Gravesham Borough Council

Lower Thames Crossing

Deadline 5 submissions

*Local Landscape Character Area boundaries of the Kent Downs AONB LCA, West Kent Downs, Sub-areas Cobham and Shorne*

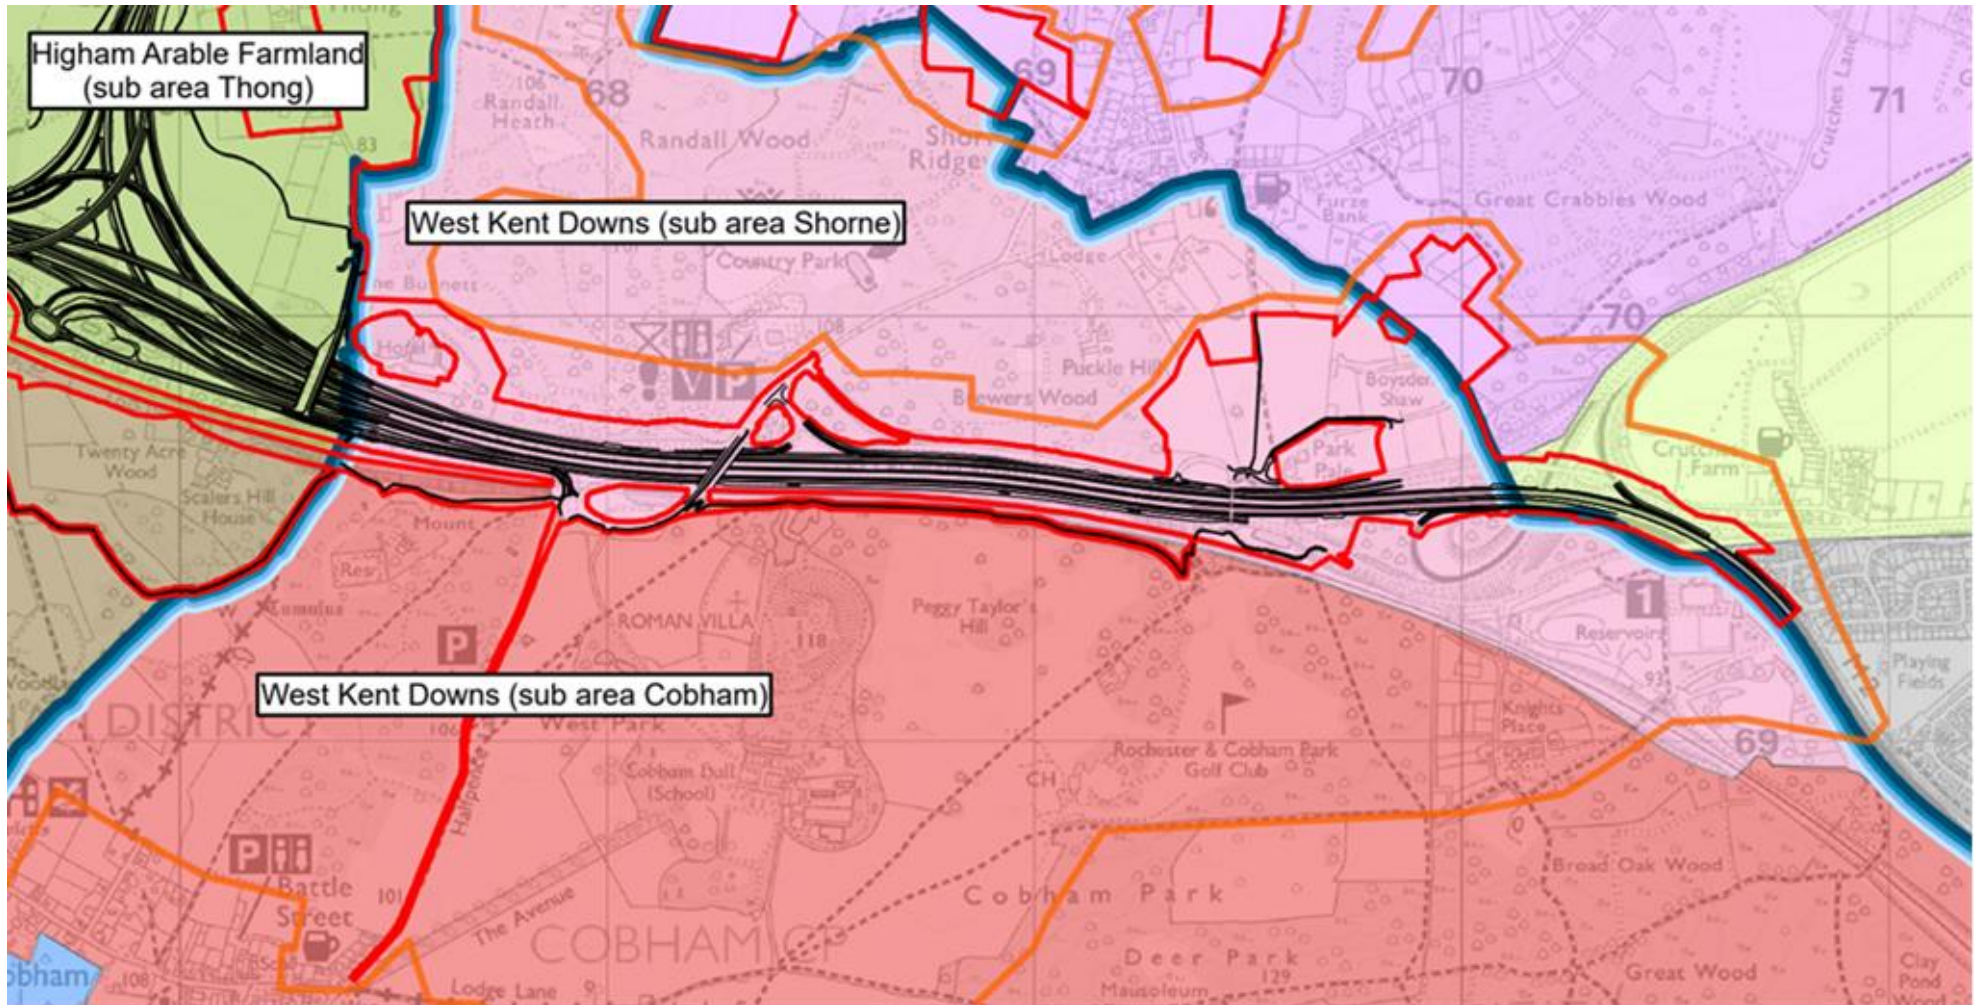
28. It is noted that the applicant has not addressed the question of the use of an incorrect boundary between the Cobham and Shorne sub areas (along HS1 rather than the A2). A fuller response on landscape matters will be provided at Deadline 6.
